Re: Tree 1005:2212-079 5214 Forest Ave SE

At your request I have reviewed the revised Lot 2 site plan and the proposed grading and retention wall within the defined root zone of tree No. 1005 on Lot 1 of the Forest Ave project. The revised Tree Plan attached shows the excavation impacts and proposed wall location. The proposal calls for excavation within about 13-feet of the face of the tree, severing about 23% of the root zone on the north side.

**3 LOT 2 TREE PLAN**  
SCALE: 1/8" = 1'-0"

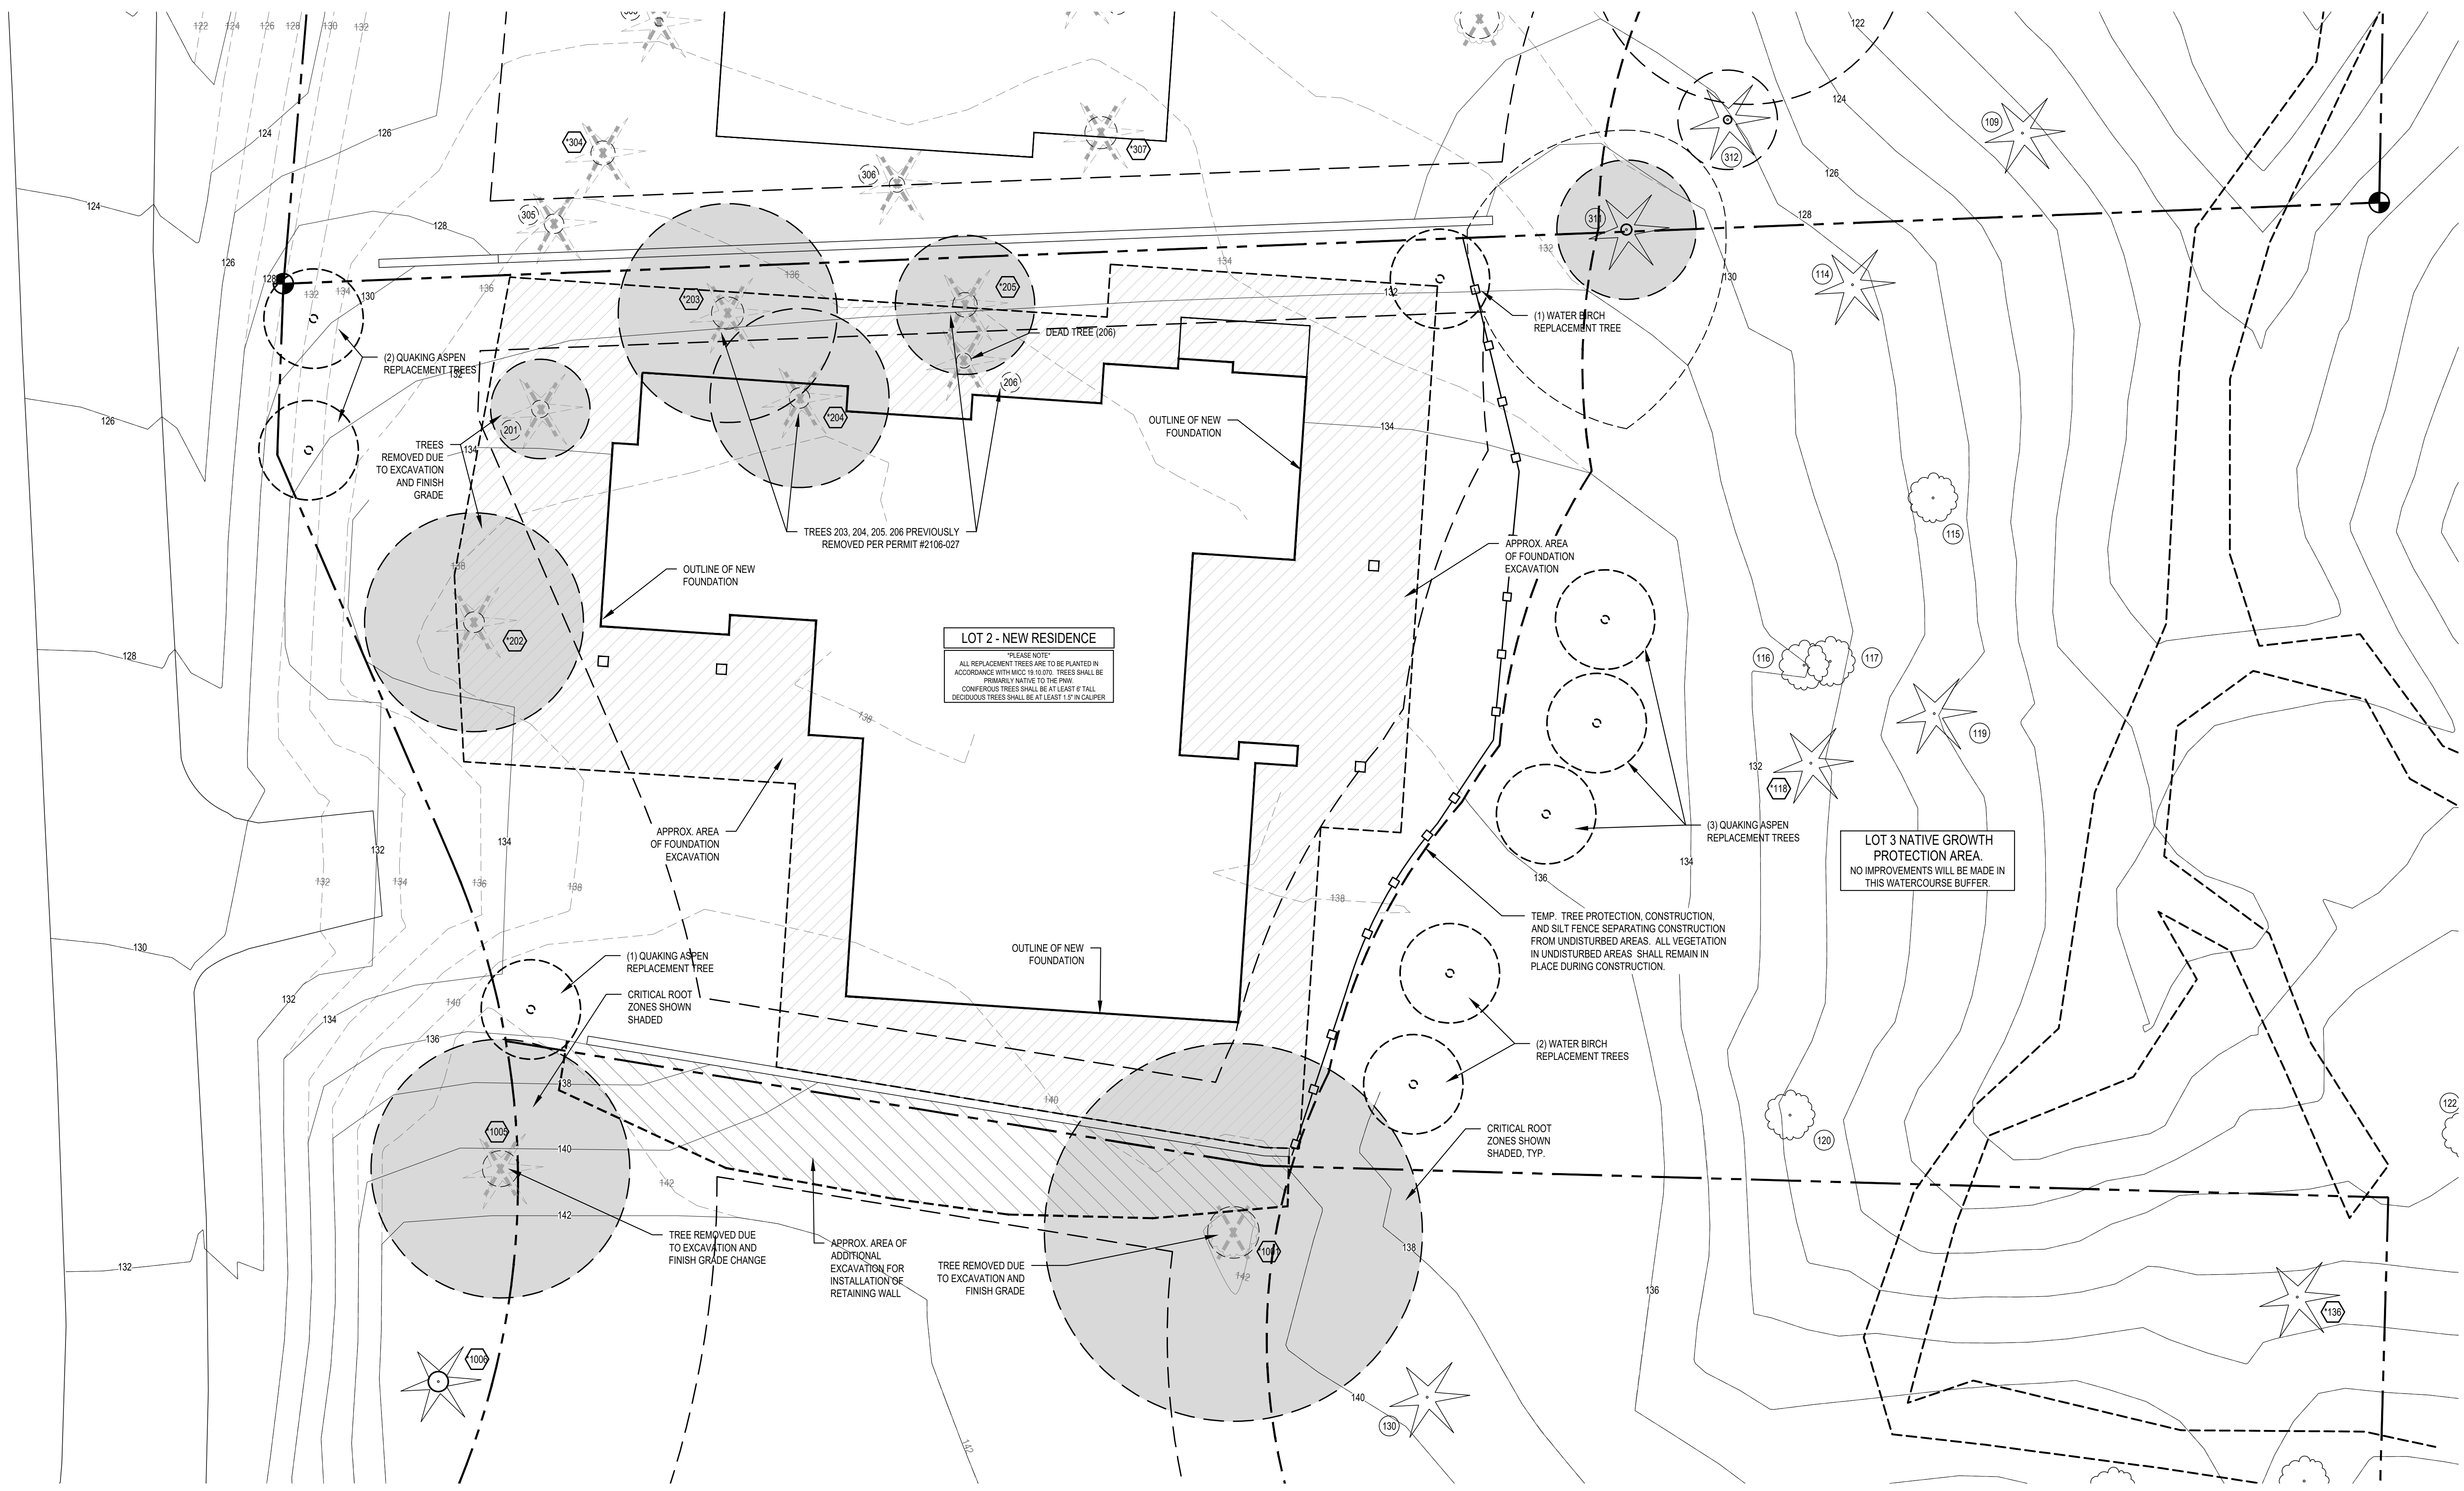
Typical Best Management Practices (Methany and Clark, 1998) suggest a root protection zone of about 31-feet for this tree ($.75 \times 41' = 30.75'$). However, this tree is already perched on the north and west sides at about the dripline with no visible roots at the dripline or former excavation limits. Best Management Practices, based on my experience indicates that encroachment that preserves at least 30-percent of the root zone is acceptable provided the tree has no other conditions that might render it susceptible to failure.

In my opinion the tree could withstand the proposed encroachment with the construction of the retaining wall understanding that no other impacts to the tree will occur with the development of lot one. And of course, there is no guarantee that any tree in any condition or circumstance will survive.
